Our Ref: AW/315/18/HH

**Town & Country Planning Act 1990 (as amended)
Town & country Planning (Development Management Procedure) (England) Order 2015
Application for Planning Permission for Works or Extension to a Dwelling**

Development Retention of fence on front, side and rear elevation.

Location 14 Churchill Avenue Aldwick

14 CHURCHILL AVE. WEST MEADS

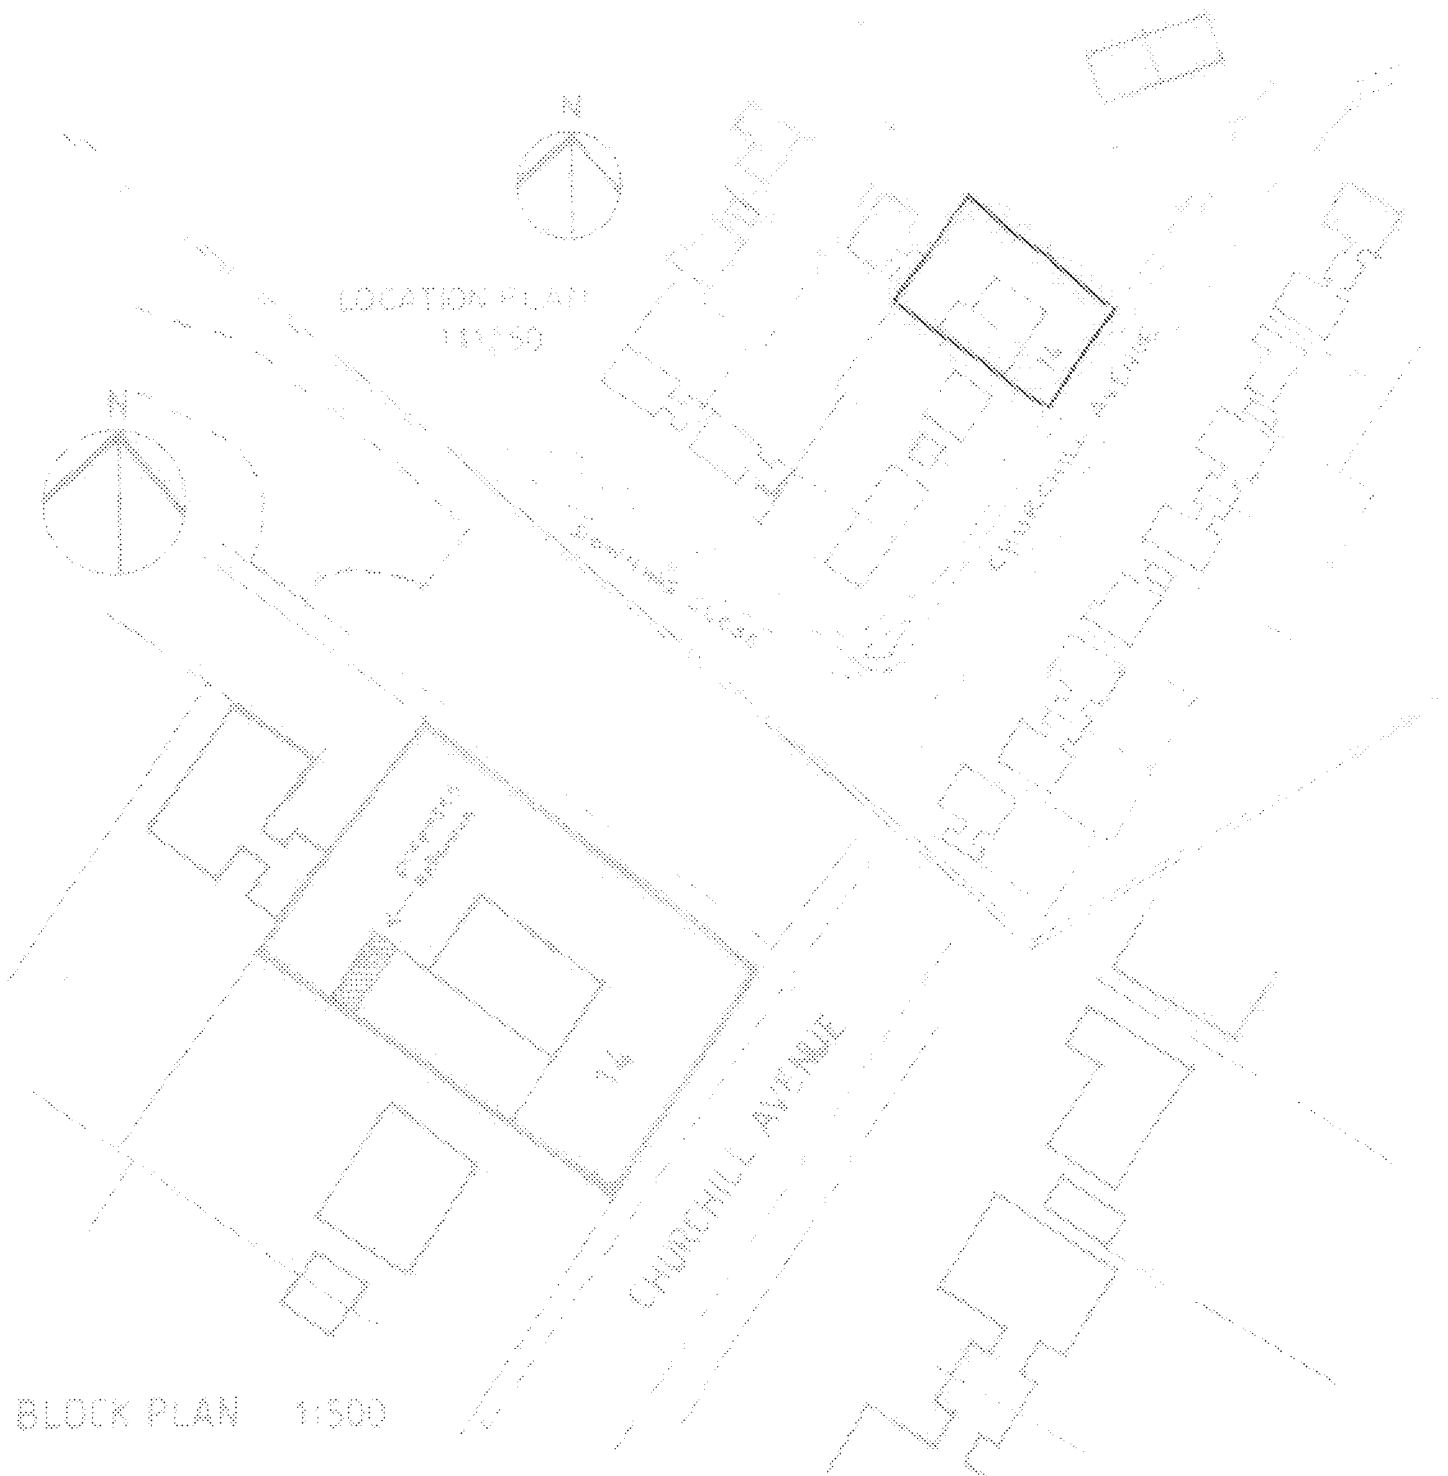
Block Plan Amend

Please provide a north point.

Please provide the measurement of the fence in metres.
